Please ask for: Mrs D Johnson
Email: daun.johnson@arun.gov.uk
Telephone: 01903 737762
Our Ref: WA/65/20/PL
Your Ref: Dr Matthews
Date: 22nd October 2020

Application for Planning Permission

Development: Change of use of upstairs of barn/garage building as occasional holiday let, use of half of one of the 3 lower bays of the garage as a workshop/office & addition of 2 wooden garage doors to the 2 open bays on the front elevation with addition of window to rear elevation (easterly bay). This application affects the character & appearance of the Walberton Green Conservation Area & may affect the setting of a listed building. This site is in CIL Zone 2 (Zero Rated) as other development.

Location: Little Box Cottage Walberton Green Walberton BN18 0AT

EXISTING LEFT (ANGLE ELEVATION)
(AND FLOORS)

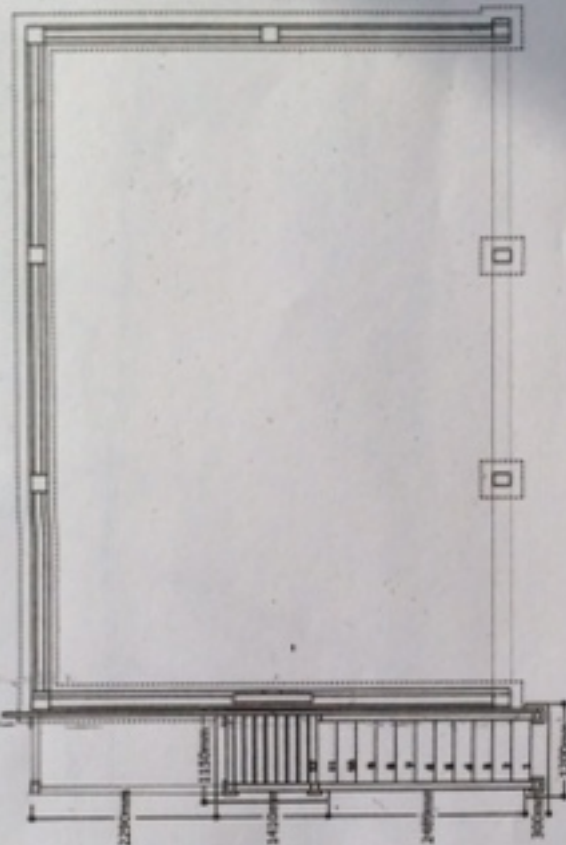
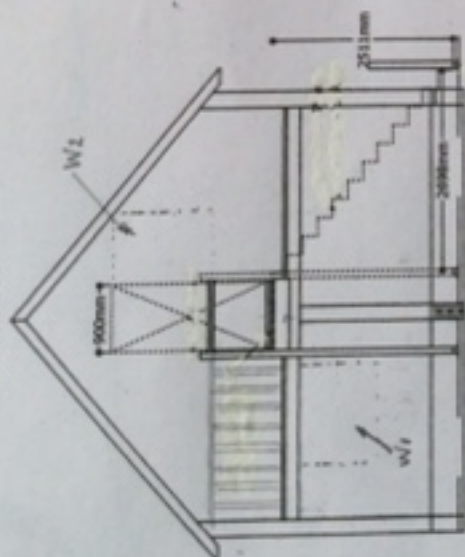
Please provide a scale of measurement in metric for the elevations. Please provide an existing and proposed side elevation to include a scale or measurements in metric. If there is no operational development for the side elevations, please label the side elevations as existing and proposed. Please label the front and rear elevations provided already as existing and/or proposed as drawn.
